KITITAS COUNTY DEPARTMENT OF PUBLIC WORKS

TO: Clay White, Community Development Service
FROM: David L. Spurlock 
DATE: February 24, 2003
SUBJECT: Peoh Point Large Lot Subdivision – Revised Comments

PEOH POINT LARGE LOT SHORT PLAT (S.P.-03-07)

RE: SP-2003-07 PEOH PT.

**PEOH POINT LARGE LOT SUBDIVISION  
A PART OF GOVT LOTS 1 THRU 8, IN THE SE1/4 AND THE SW1/4 OF  
SEC. 11 - T.19N. - R.15E., W.M.  
KITITAS COUNTY, WASHINGTON**

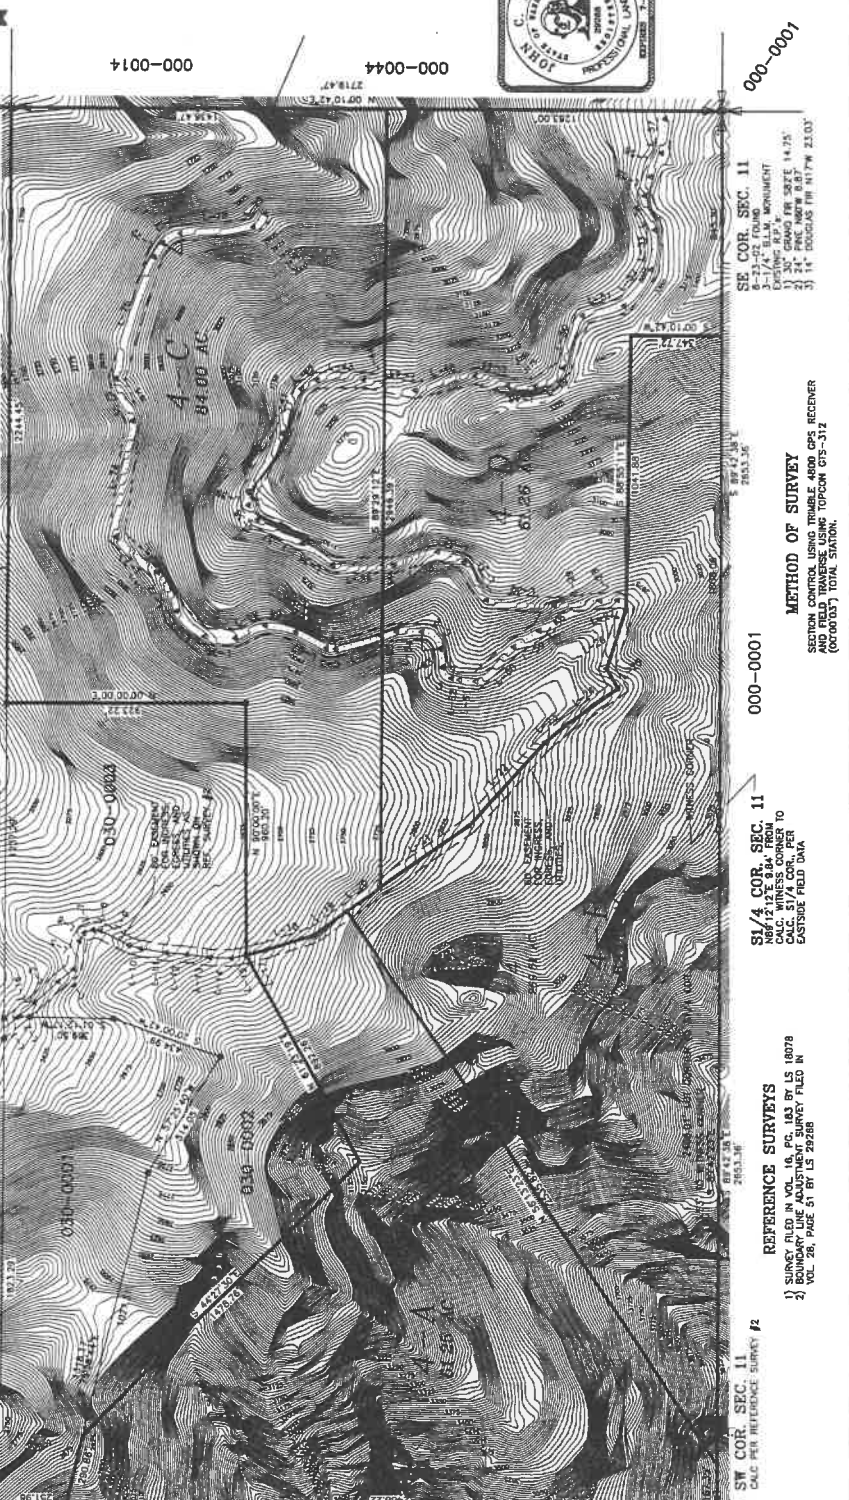
After our departments review of the final mylars it has become apparent that the applicant shall show or make reference to the access easements to the property. The question has risen that the proposed large lot subdivision did not have access to a public right-of-way. After some further review and a review of the documents that were submitted with the application it was determined that the Peoh Point Large lot Plat has access to Alice Road, which is a dedicated public right-of-way via a private easement across lot 12 of the Little Peoh Point Tract Plat. For more information please see attachments.

My concern with this proposed plat is that it implies that utilities would be available in the future to any proposed buyer. Since this property is currently being marketed as subdividable the face of the plat should be revised to make any prospective buyer aware of the fact that there is no utility easement to serve the property.

Kittitas County Community Development Service's Department is in receipt of your letter and has been reviewing it further, at the same reviewing the preliminary drawing submitted with the application. I would like to point out that your comment is well received, but after further review, on the face of the preliminary drawing it does state that there is a 60 foot easement for the purposes of ingress, egress, and utilities as shown on Ref. Survey No. 2. Please review the preliminary drawing that was given to you at our previous meeting.

Since there is already language on the face of the plat stating the easement location for ingress, egress, and utilities, therefore negates requiring a note stating there is no utility easement to serve the property.

DRAWN BY: K. HORTON	DATE: JUNE 3, 2003	JOB # 02-272LL dwg
CHECKED BY: KEVIN BLUHM	SCALE: 1" = 300'	COMP 4 02-272
		SHEET 1 OF 2

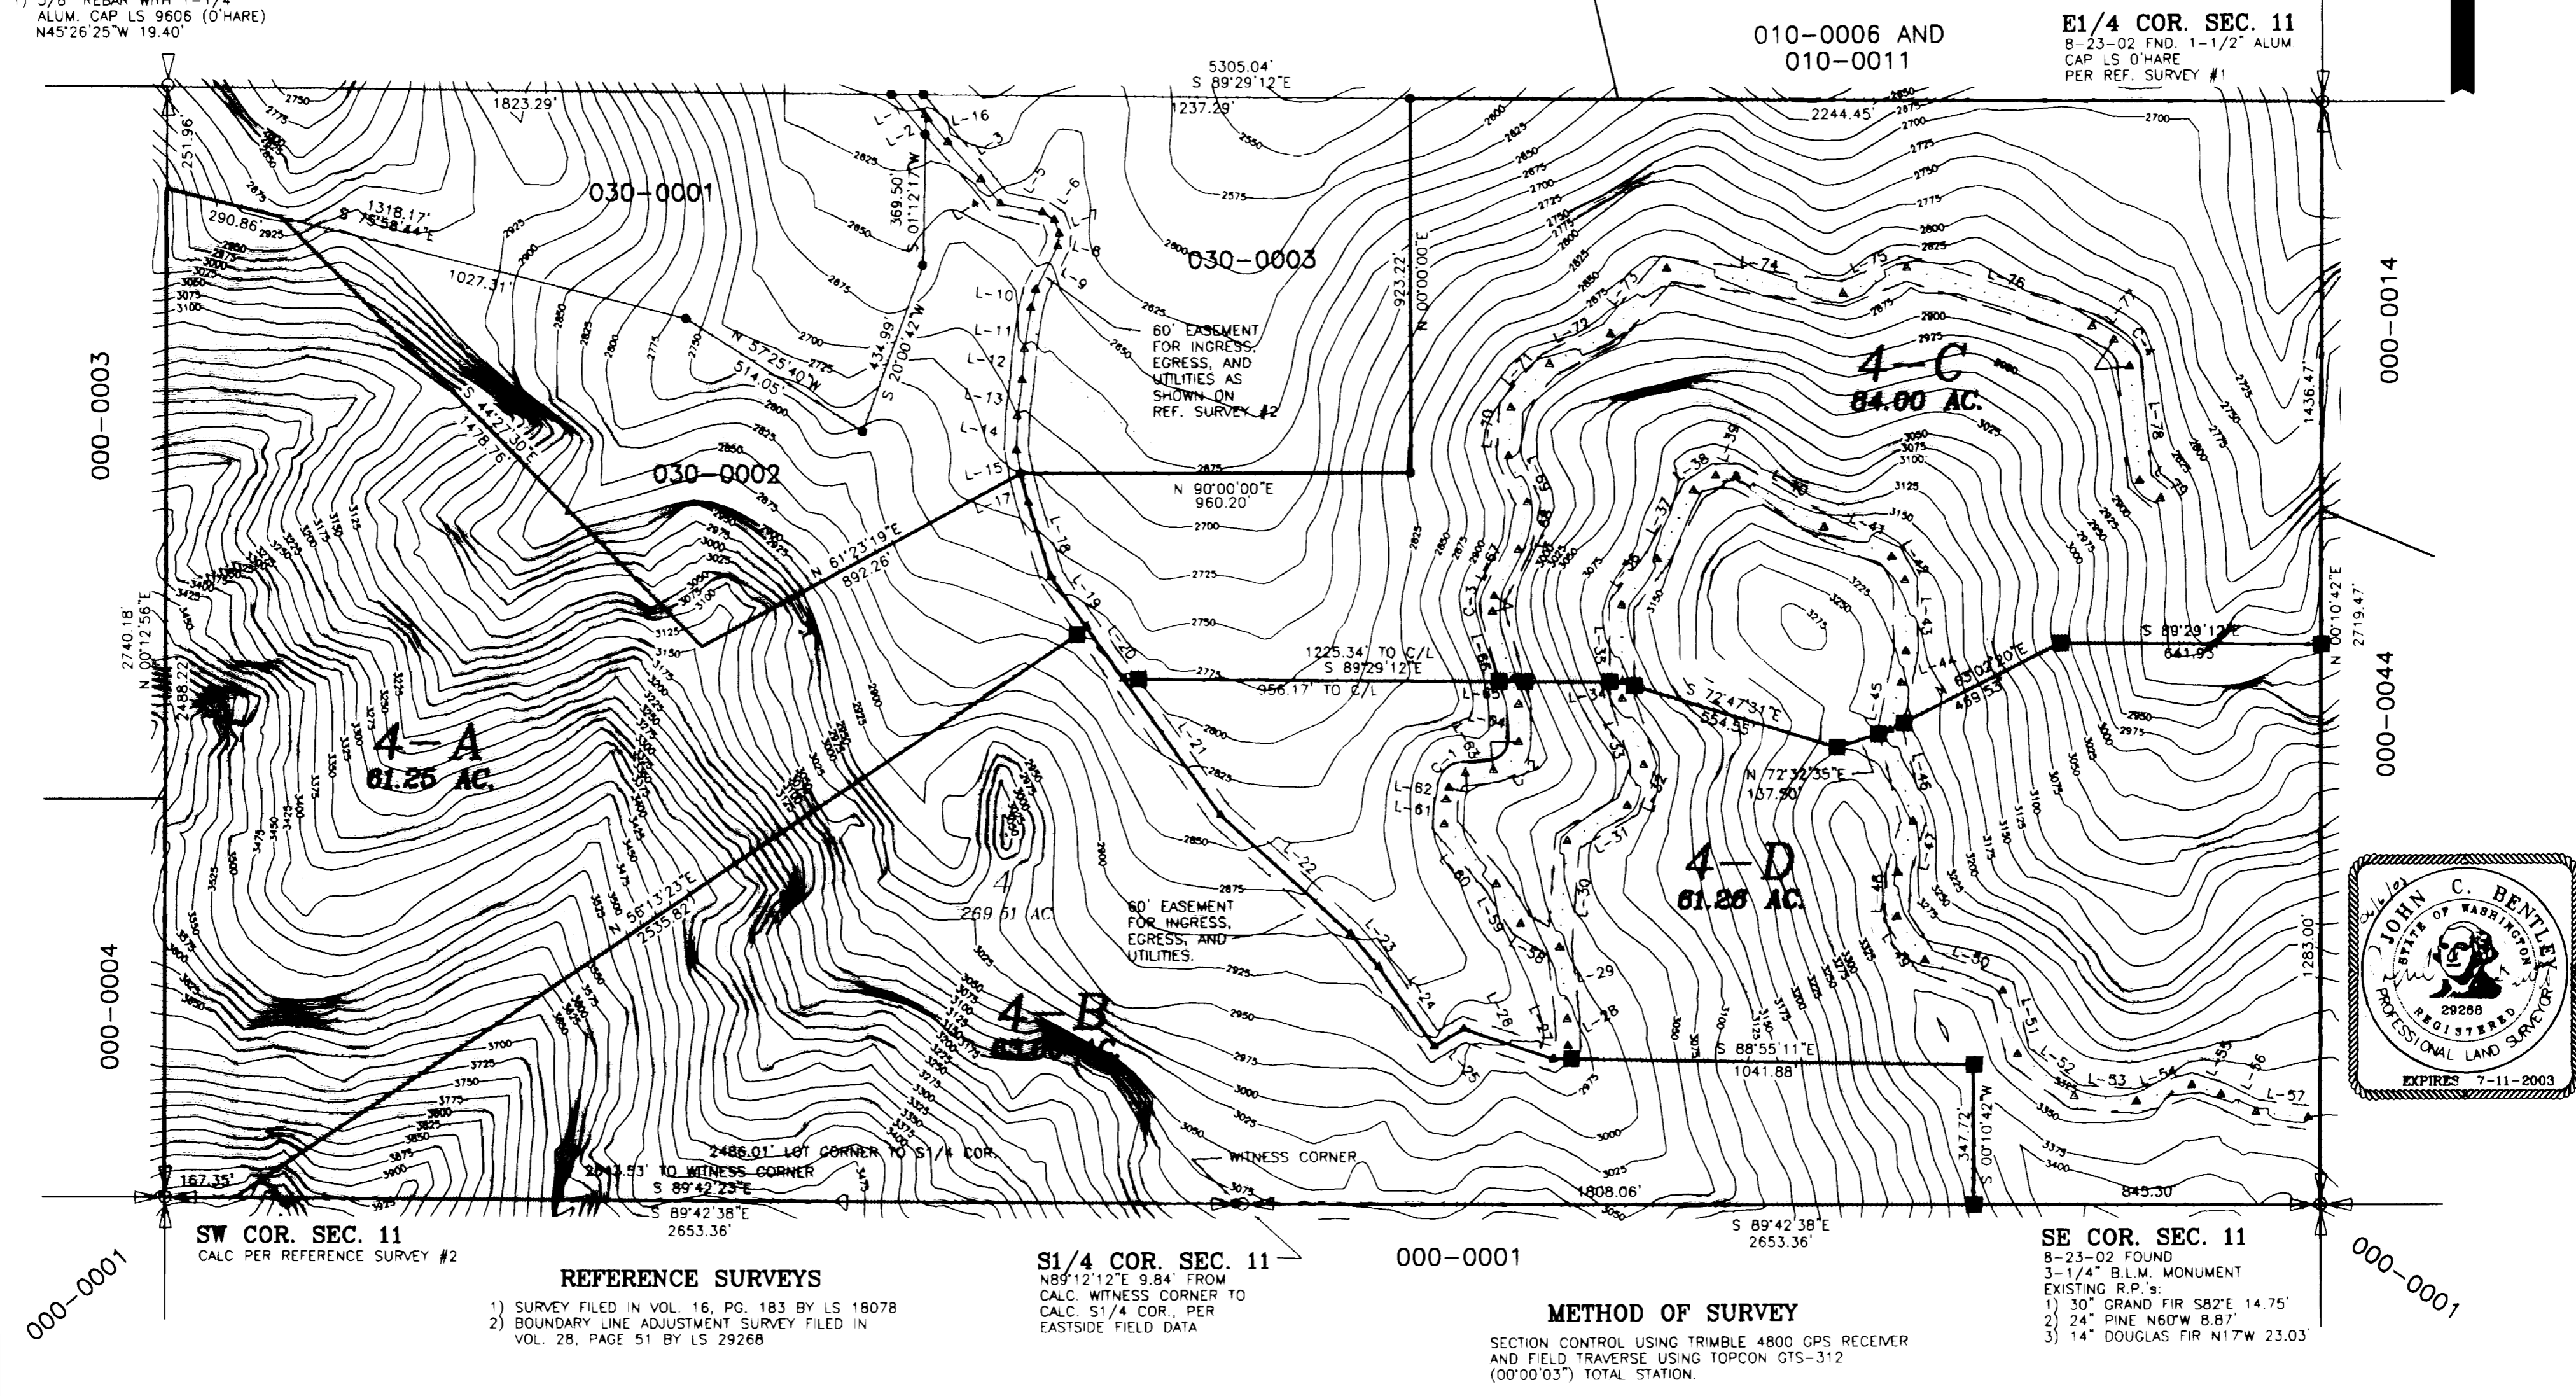
1. Plat notes shall reflect the following:
 - a) Entire access to all lots must be constructed to the Uniform Fire Code as adopted by Kittitas County prior to the issuance of any Building Permit.
 - b) The cumulative effect of water withdrawals for this development shall not exceed 5,000 gallons per day.
2. Attached you will find comments from the Kittitas County Department of Public Works and KC Environmental Health. Also attached is a copy of the survey with some minor revisions that are needed for the final mylar's. Please let me know if you have any questions.
3. Survey must meet the provisions of KCC 16.24. Specifically, property corners must be set.
